From: Laura Gibbons
Sent: 26 October 2018 13:39
To: Planning.Responses
Cc: David Easton
Subject: AL/44/18/RES: Oldlands Farm

Engineers Comments Regarding Surface Water Drainage

Project No:	Scale (@A1):	Drawn:	Date:
1620003993	1:750	JAC	APR.18
Drawing No:	Rev:		
RAM-0500-02-DR-CR-00001	P07

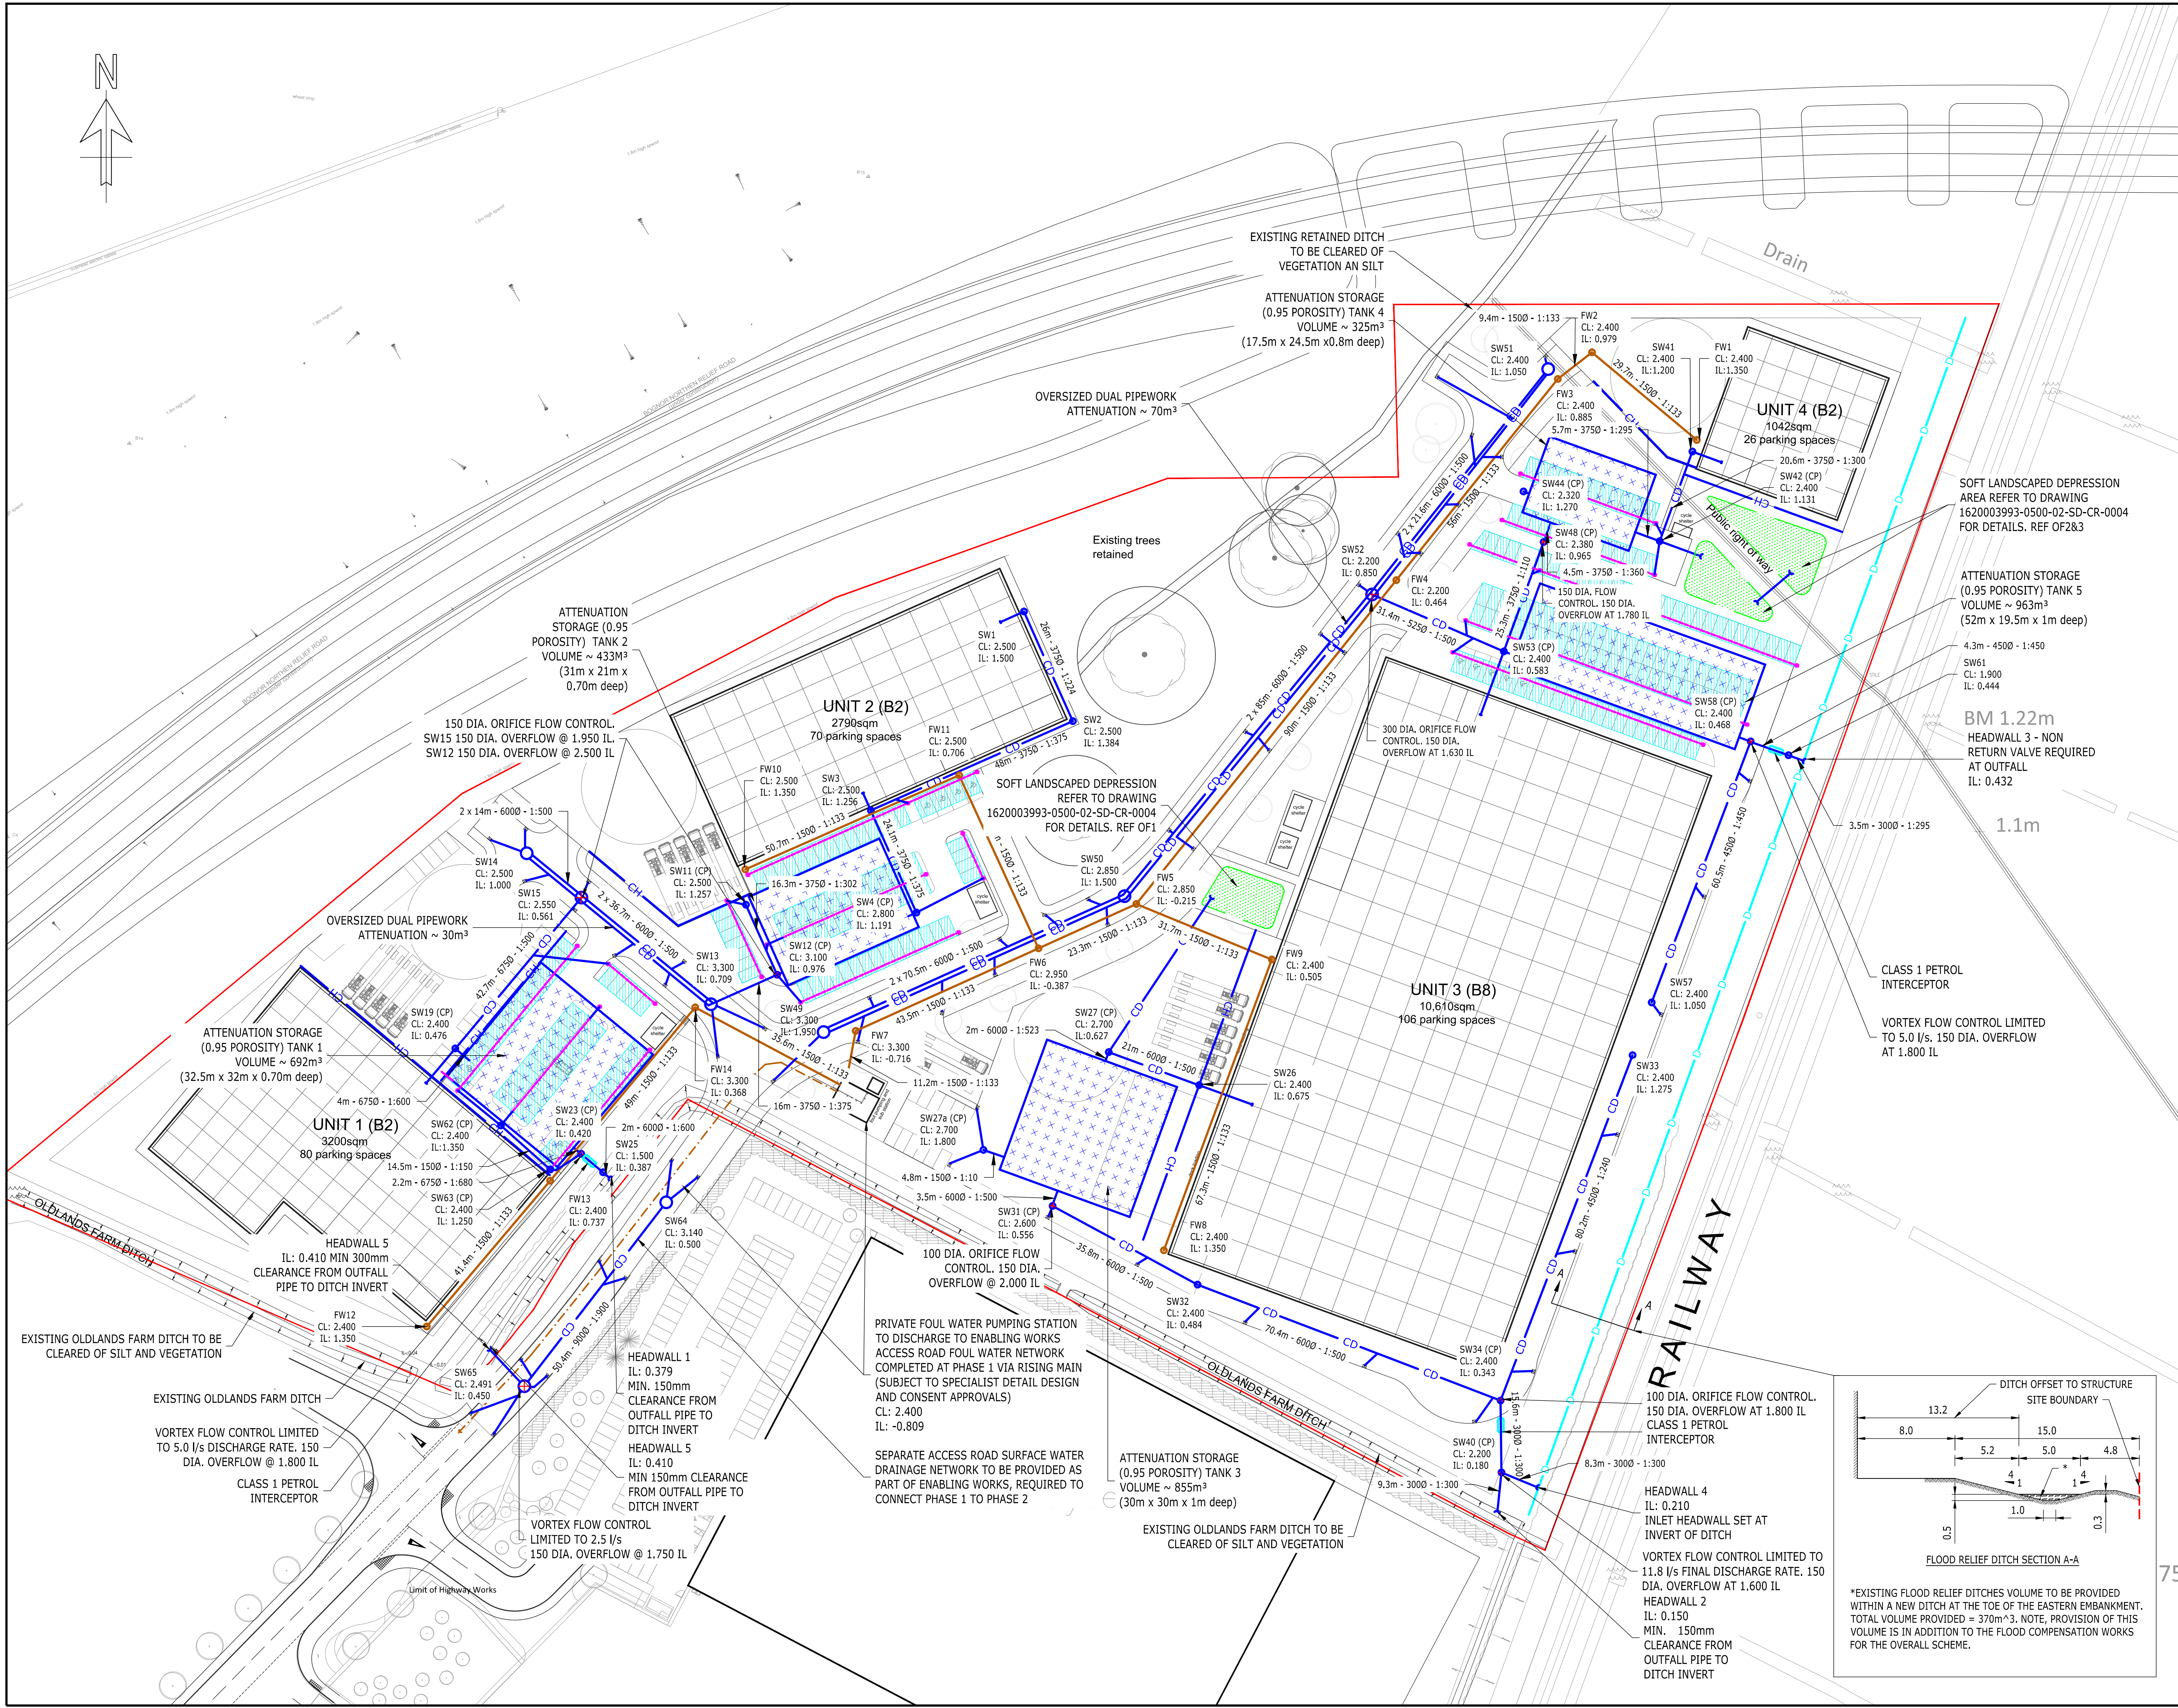
Formal consent to culvert a section of Oldlands Farm Ditch has not been obtained to date. However, plans have been provided which detail the proposed site layout including the areas around the ordinary watercourse. I therefore recommend that condition 18 is discharged and development occurs in accordance with the layout plan (1620003993-RAM-0500-02-DR-CR-00001-P07) and Condition 20 remains which covers these outstanding issues.

I recommend that condition 22 is discharged as the submitted documents demonstrate that the hierarchy for sustainable drainage has been followed and the proposed drainage should adequately drain the site. Development should occur in accordance with the following documents: *1620003993-RAM-0500-02-DR-CR-00001-P07*, *1620003993-RAM-0500-02-SC-CR-00001-P05*, *1620003993-RAM-0500-02-SD-CR-00004-P02*, *1620003993-RAM-0500-02-SD-CR-00001-P01*, *1620003993-RAM-0500-02-SD-CR-00002-P01*, *1620003993-RAM-0500-02-SD-CR-00003-P03*, *1620003993-RAM-DR-CB-00003-P02*, *1620003993-RAM-DR-CB-00004-P01*.

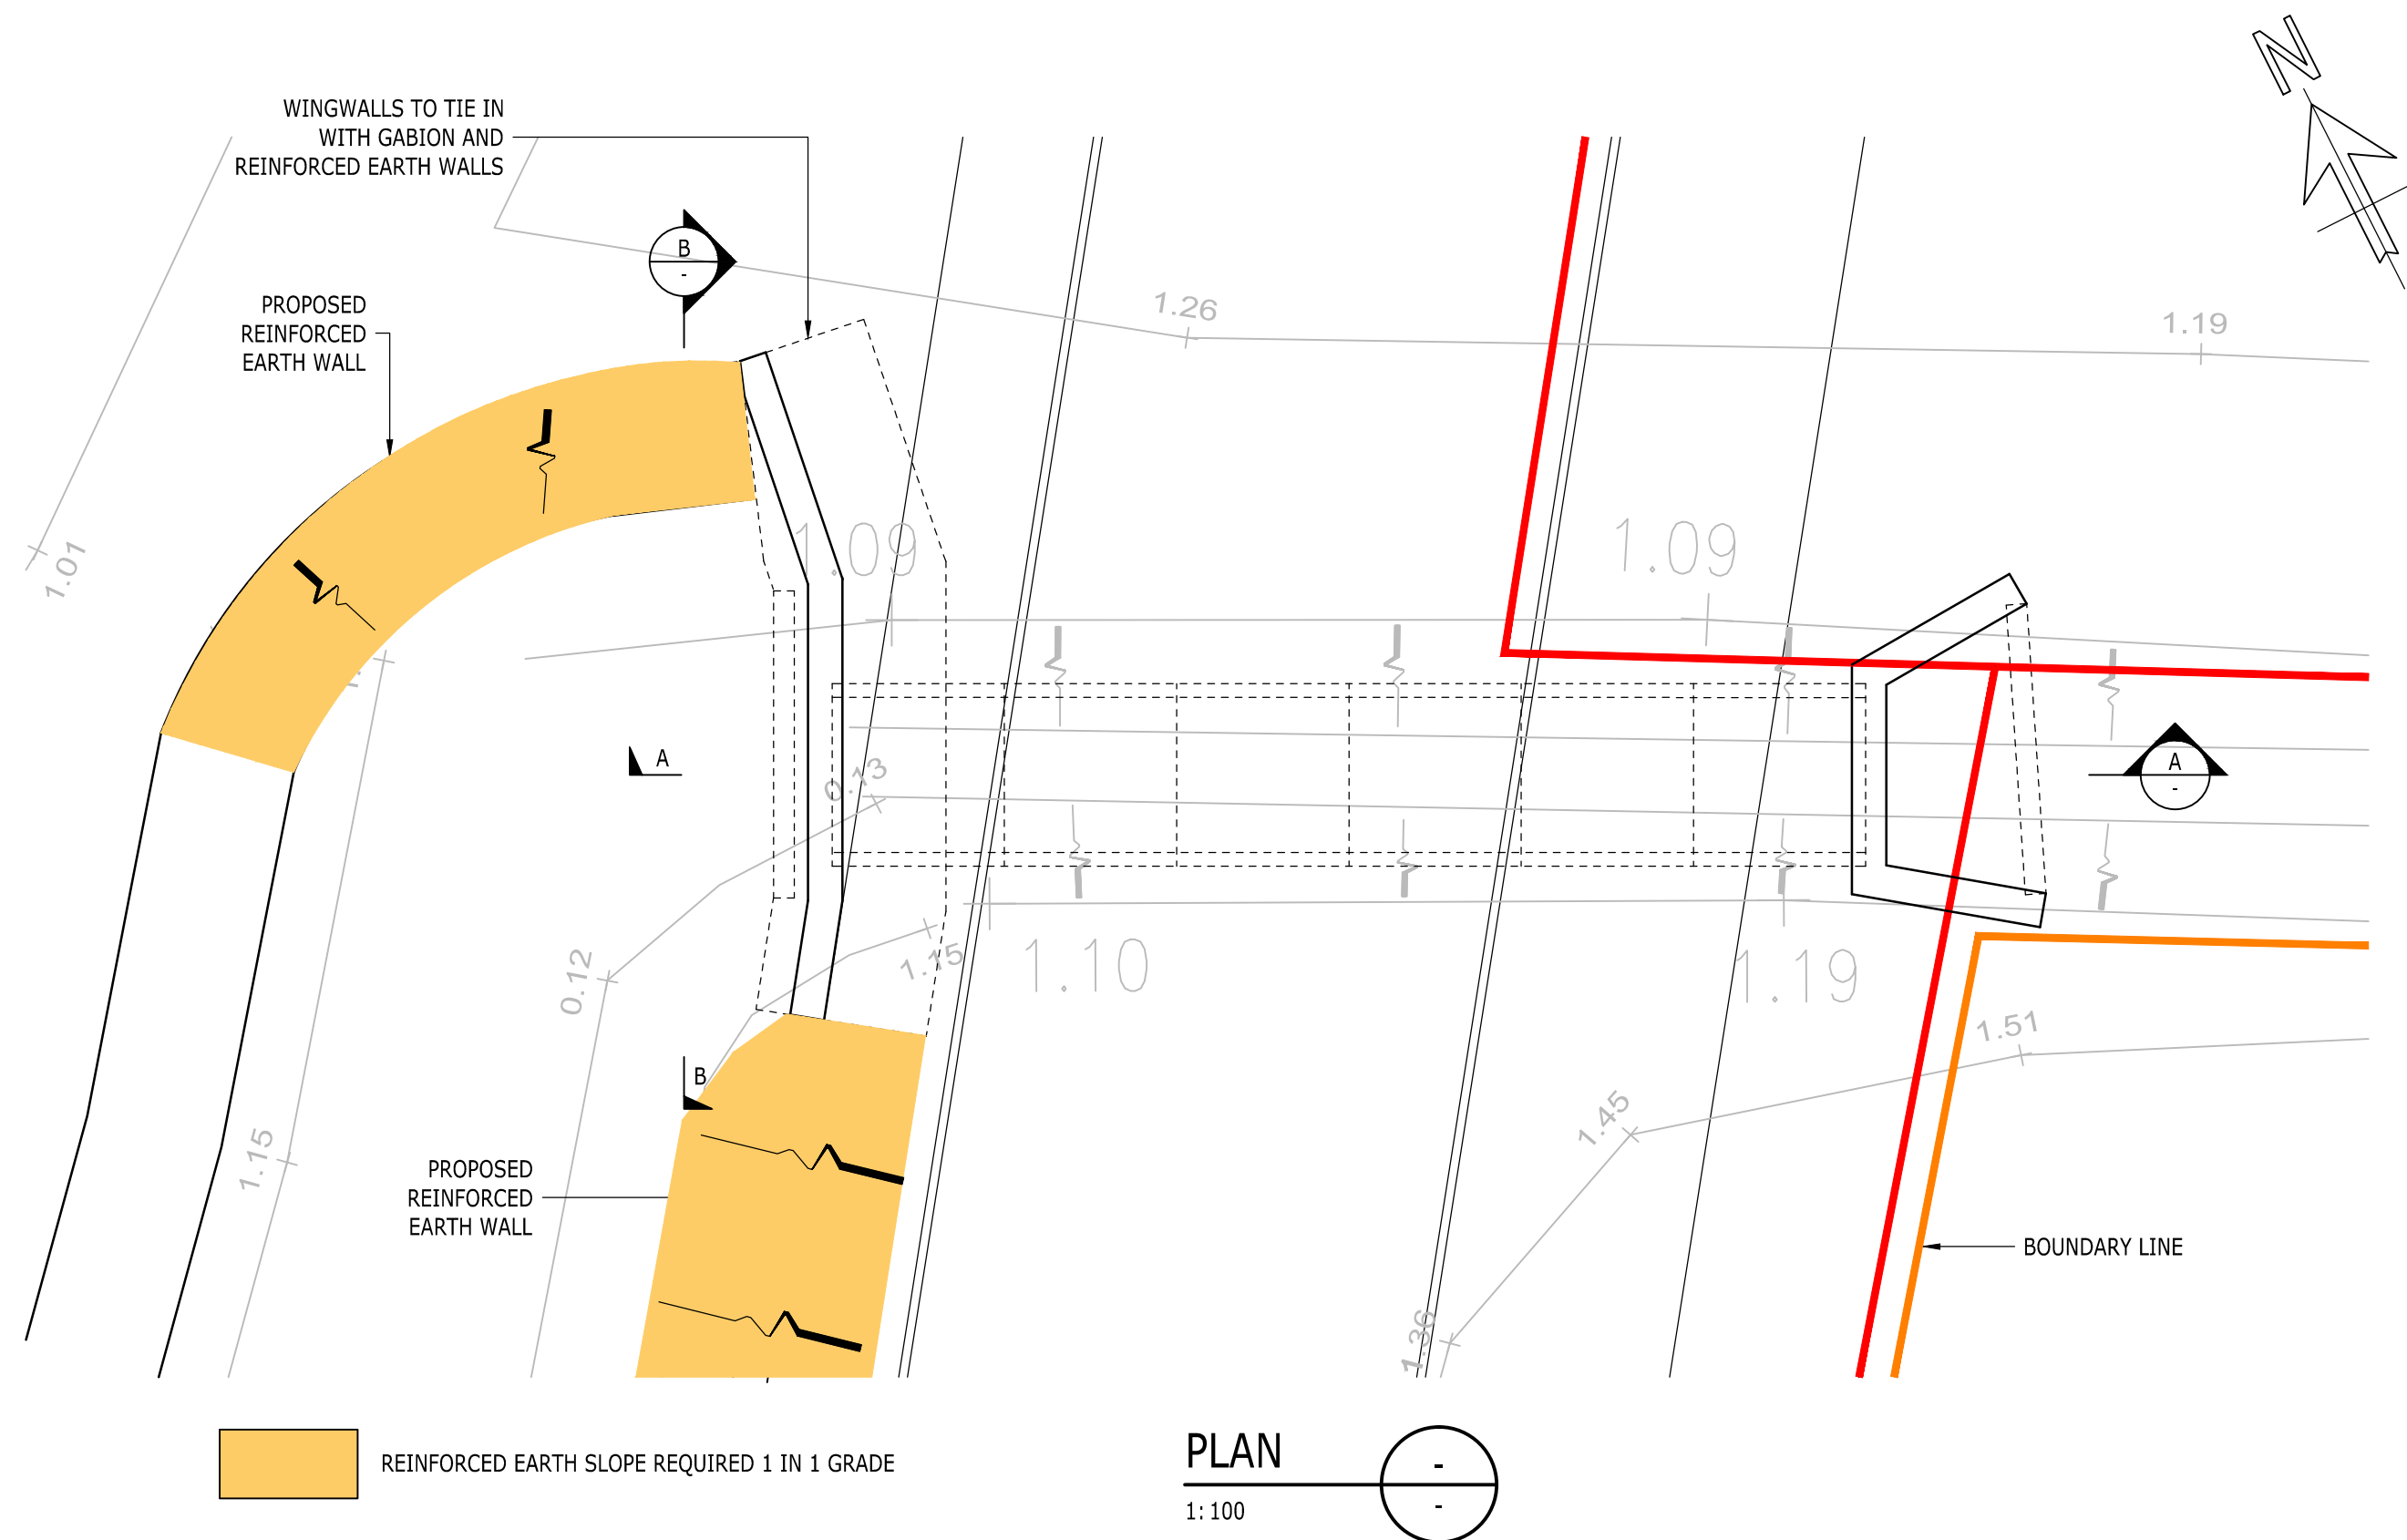
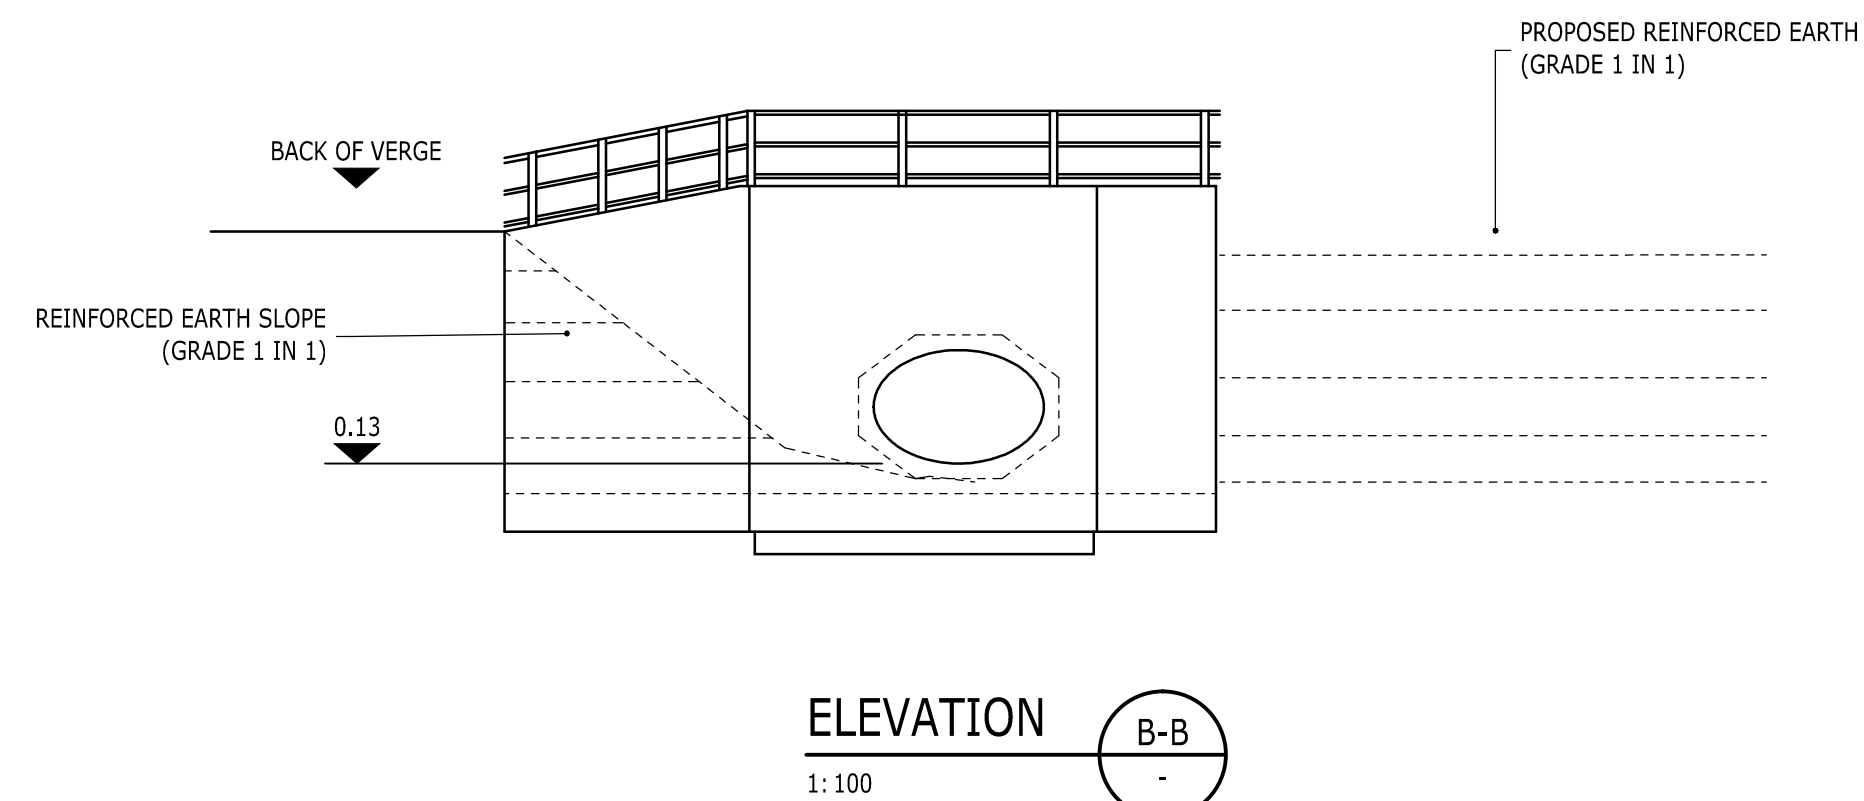
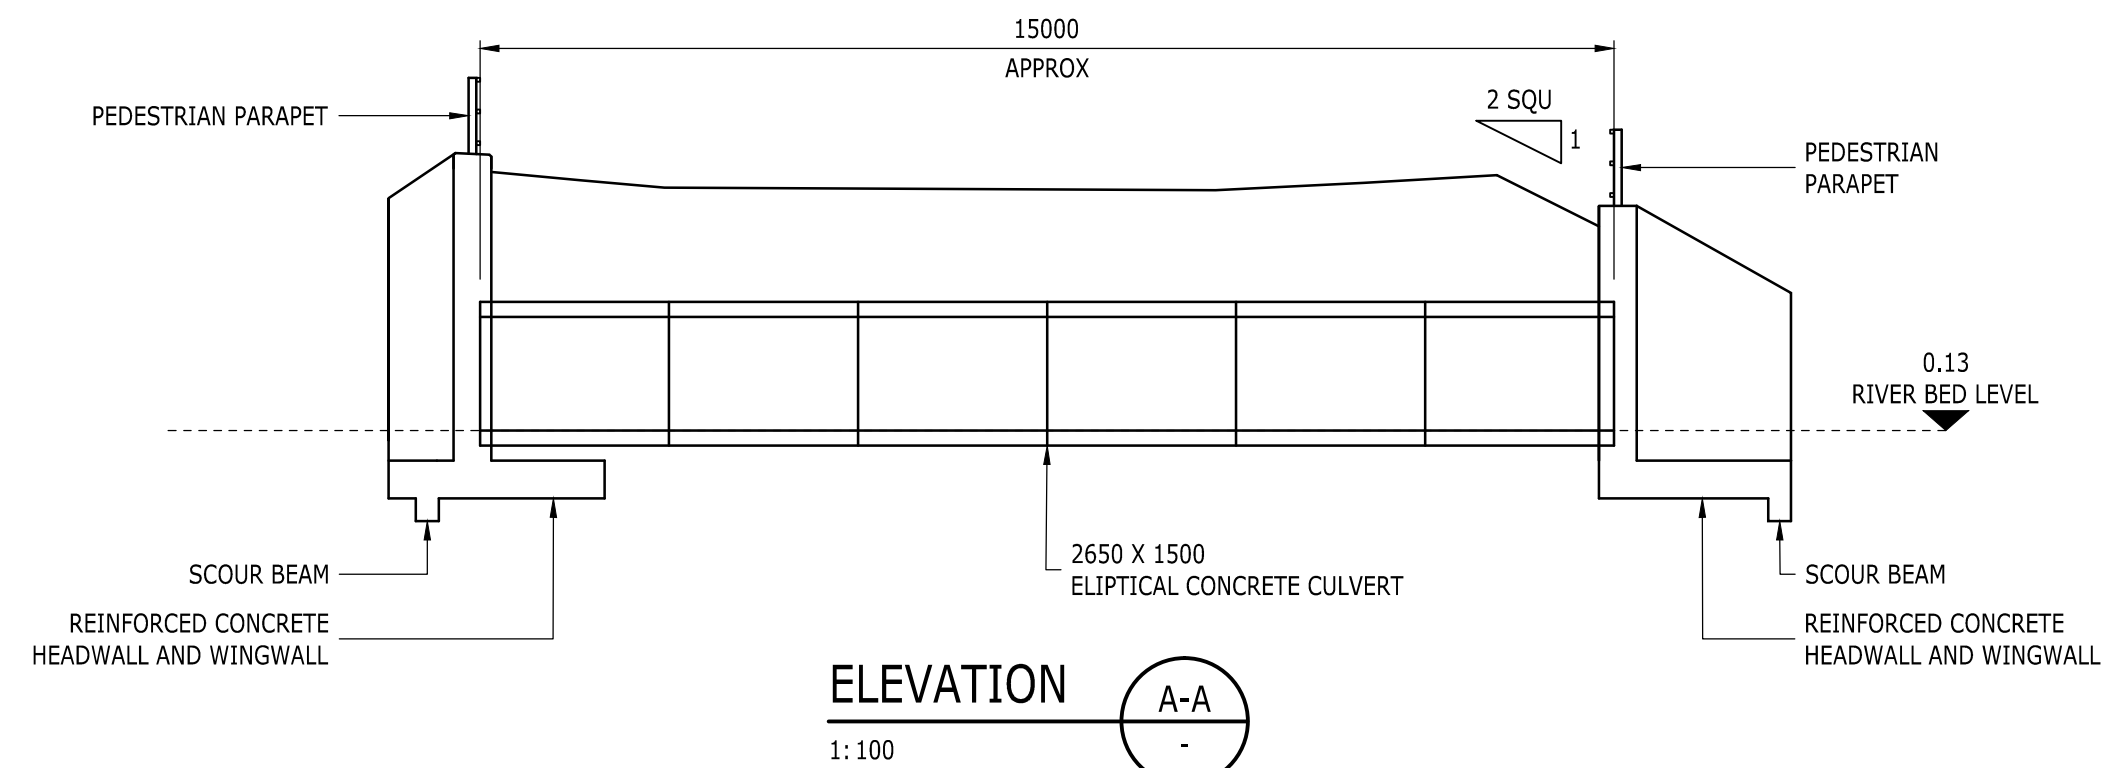
We have received plans for the construction of a culvert along Oldlands Farm Ditch (1620003993-RAM-DR-CB-00003-P02 and 1620003993-RAM-DR-CB-00004-P01). Plans also include for the infilling of three ordinary watercourses and the construction of a new watercourse. Ordinary Watercourse Land Drainage Consent has not been obtained to date for the following three activities: Culverting of oldlands farm ditch; infilling of ditches and construction of new ditch; and the proposed outfalls to Oldlands Farm Ditch. This condition will be reviewed and discharged following a formal discharge of consent application.
